The Member Secretary,  
Chennai Metropolitan  
Development Authority,  
No.1, Gandhi Drive Road,  
CHENNAI -600 004.

Letter No. 12/17726/2023

Sub: CMDA - Planning permission - Proposed const-  
ruction of Factory Building at Plot No.82 &  
83, S.No.8/1A/B and 8/1B of Parangudi Village -  
Development Charges and other charges to be  
submitted - Regarding.

PLAN SHOWING THE PRO INDUSTRIAL BUILDING FOR 'M/S JAYAM FORMS' IN S.N.B.11A/B, #18 PLOT NO E2, E2, DOOR NO T&B, NEHRU NAGAR 3rd CROSS ST, PERUNGUDI VILLAGE, CHENNAI. SCALE: 1/11 TO B10/11 MANUFACTURERS OF COMPUTER FORMS

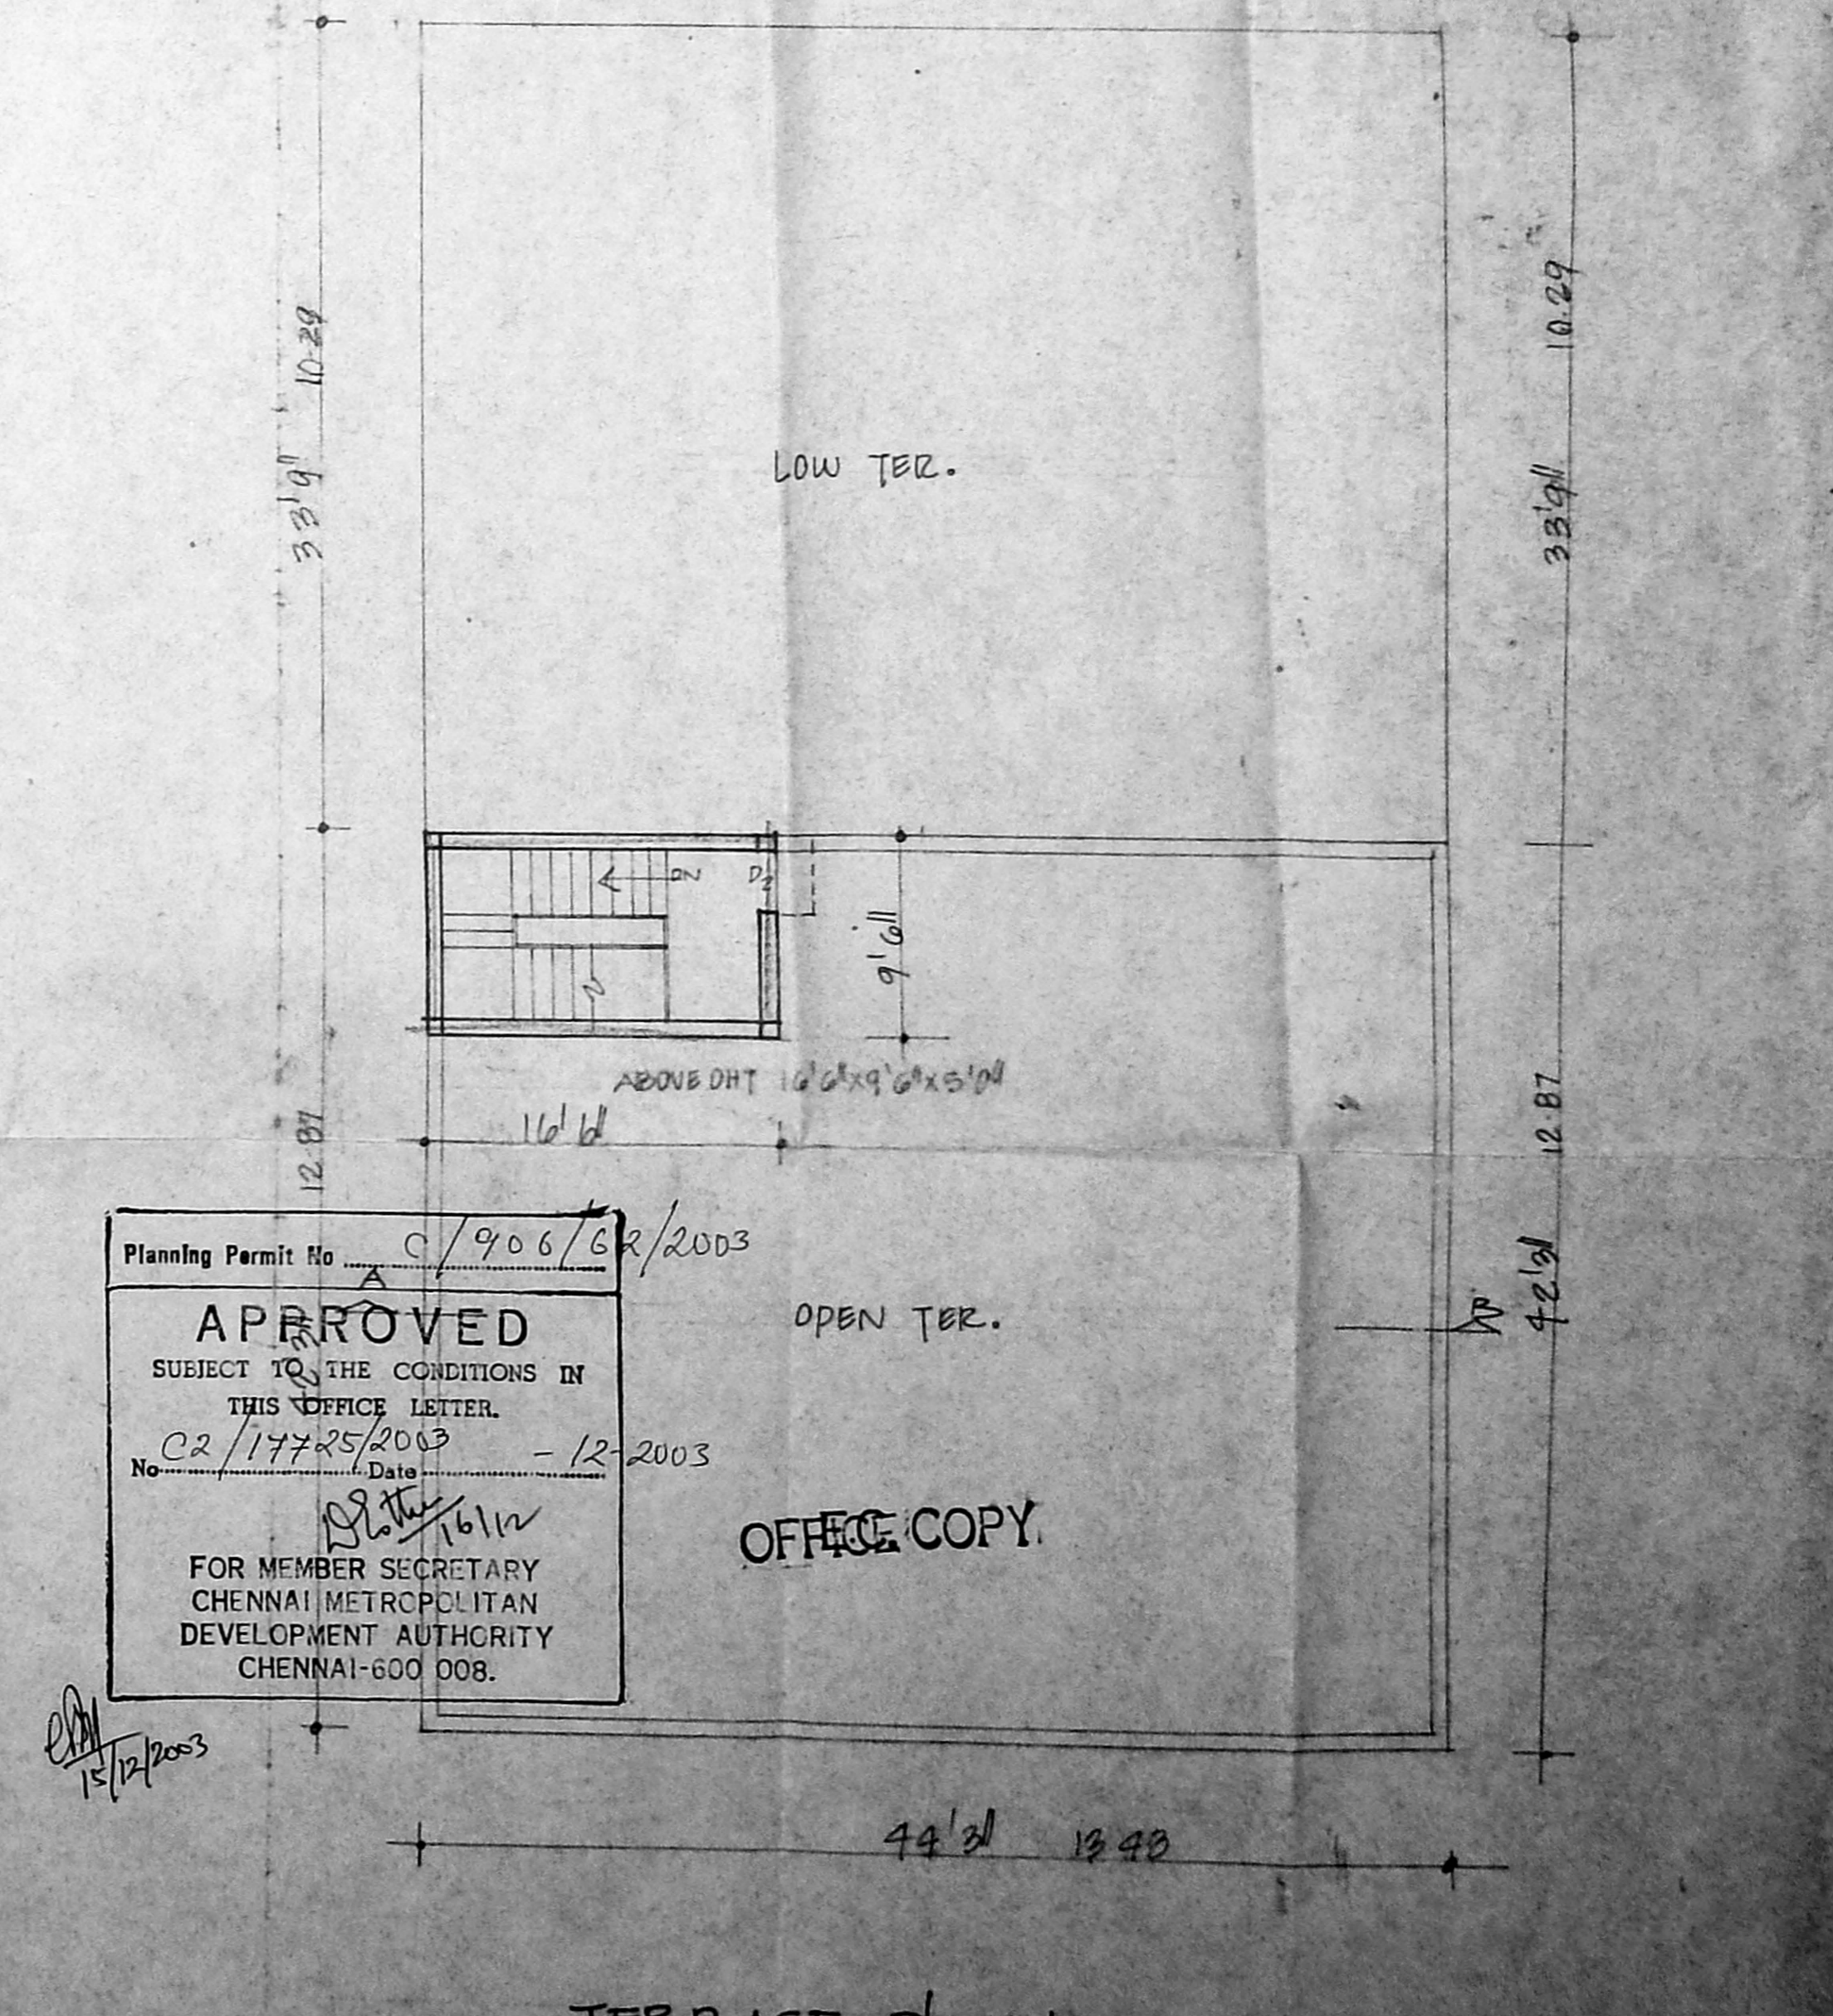
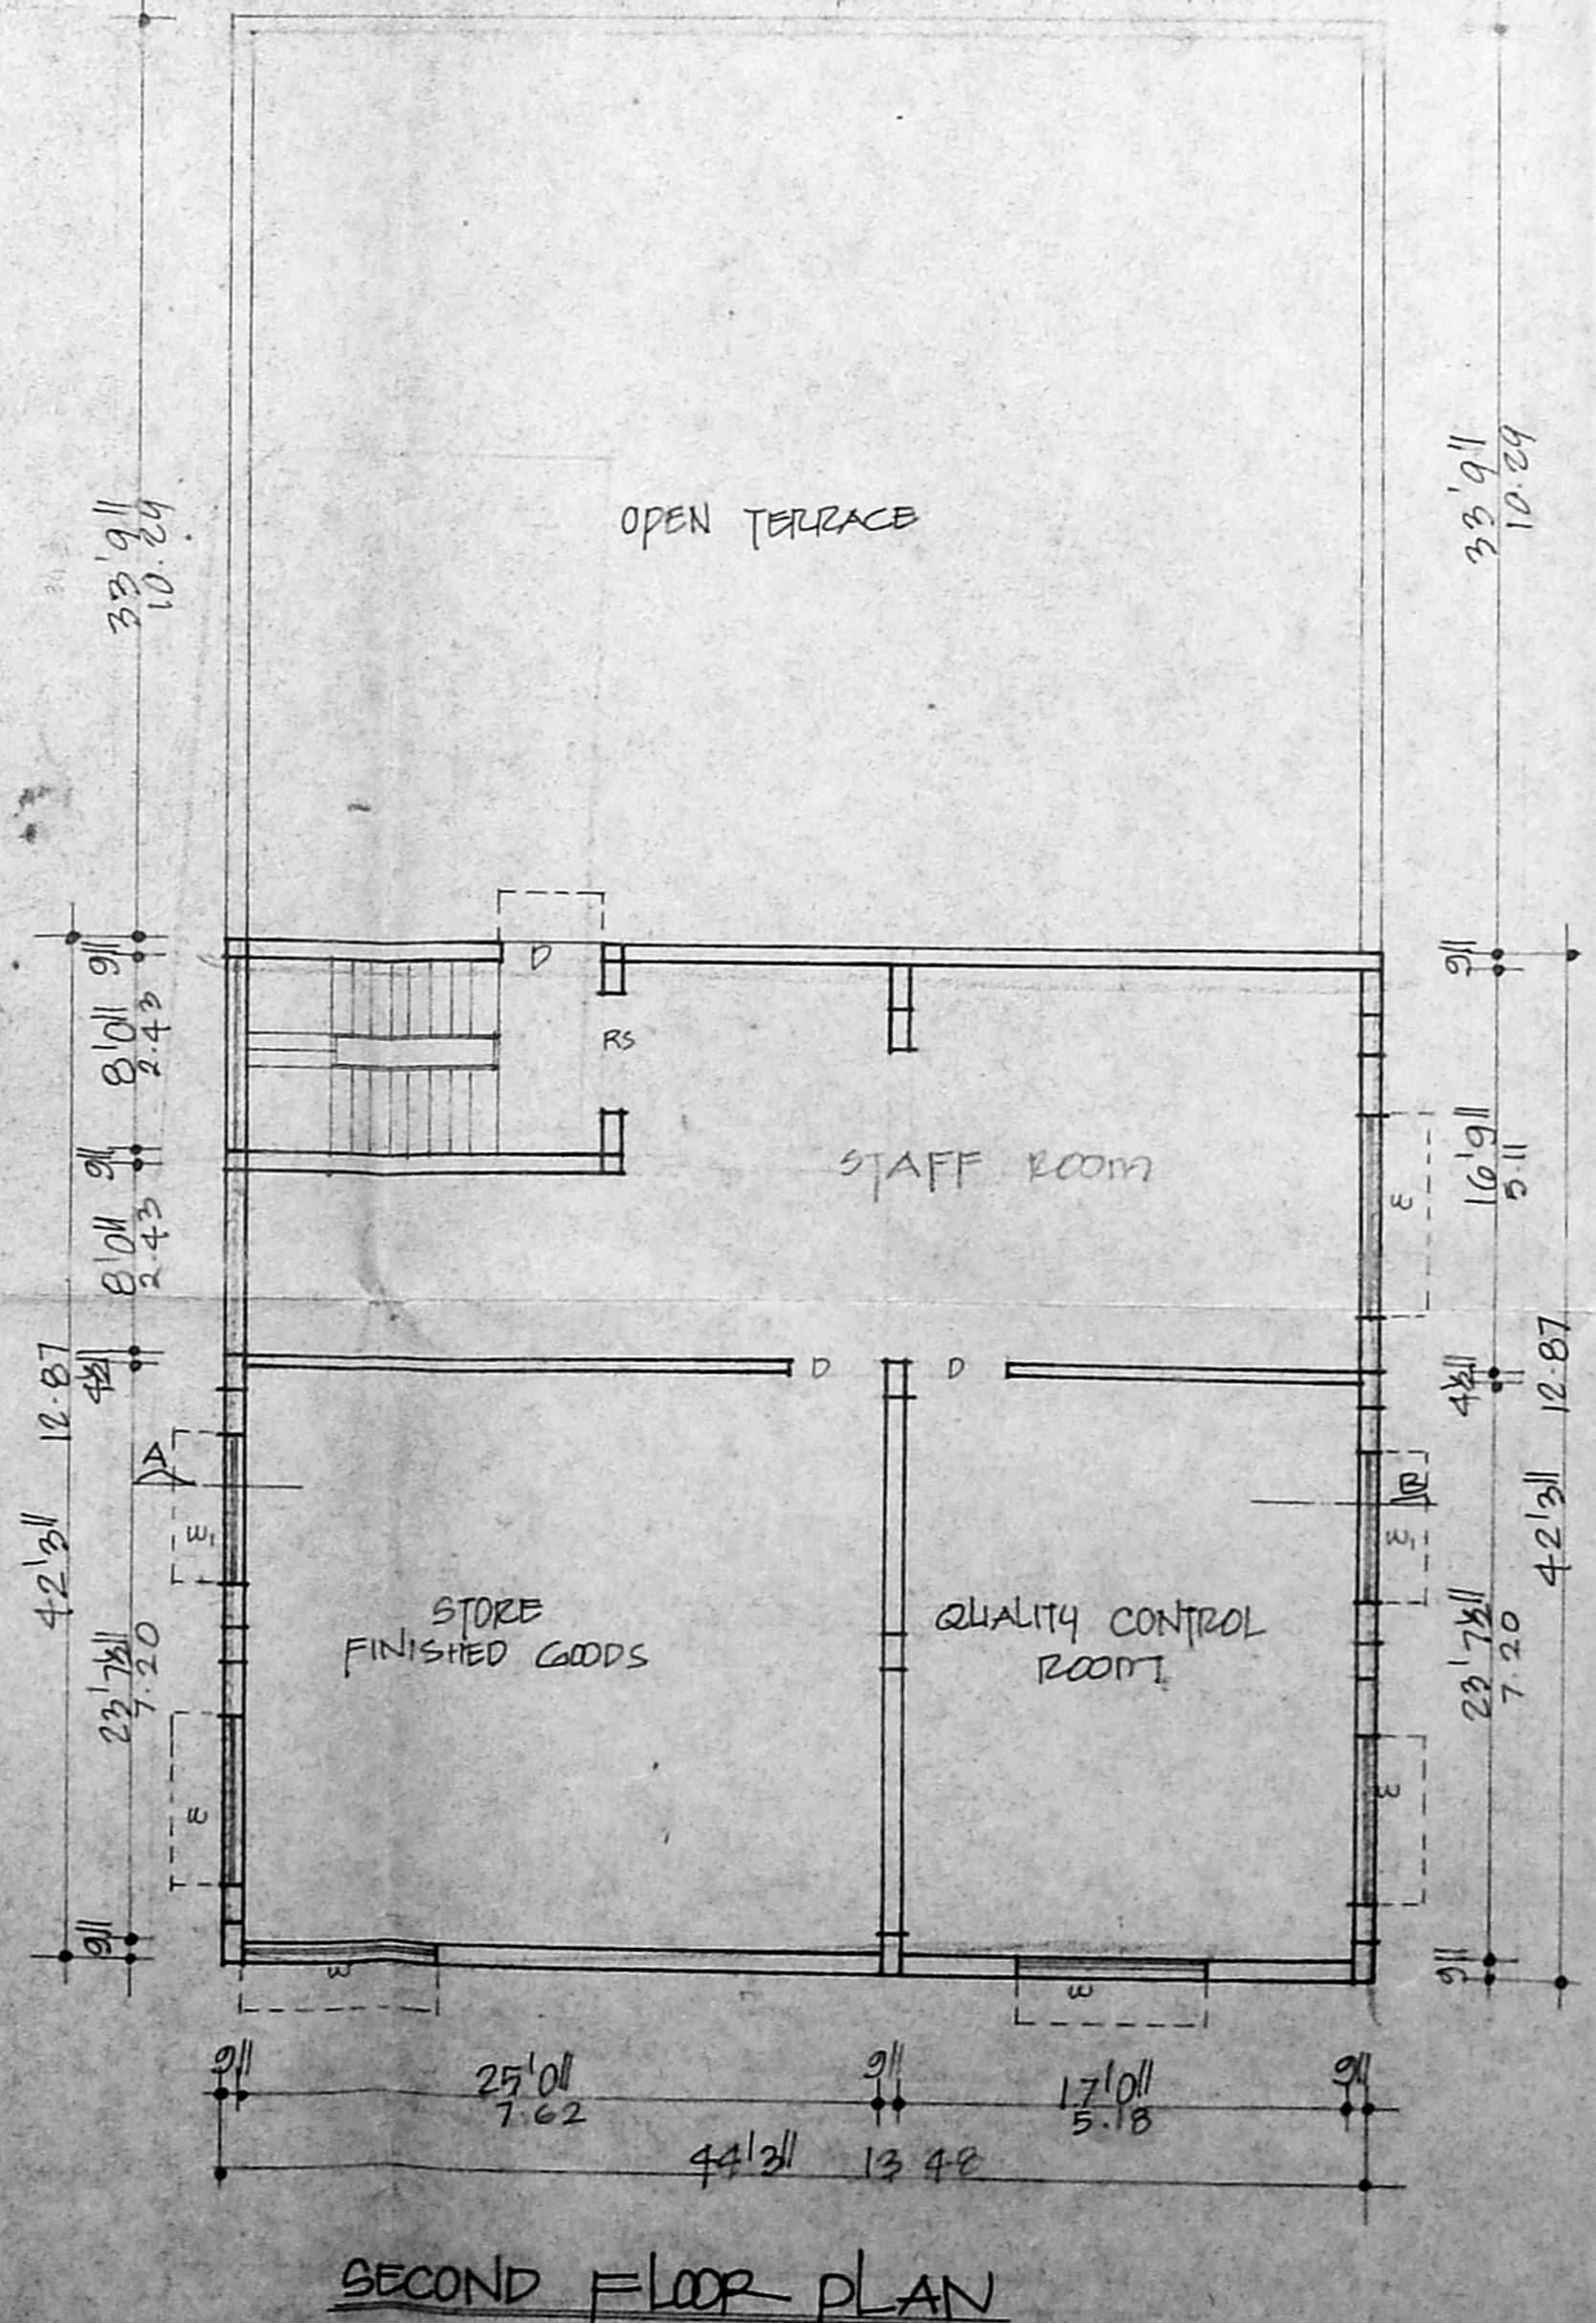
- a) Rain water conservation measures notified by CMDA should be adhered to strictly.
- b) Revised plans restricting Floor Space Index to 1.00 (least extent as per plan).
- c) Valid Tamil Nadu Pollution Control Board consent letter (latest) for the site under reference i.e. Survey No. 4/1A/B and 4/2A.
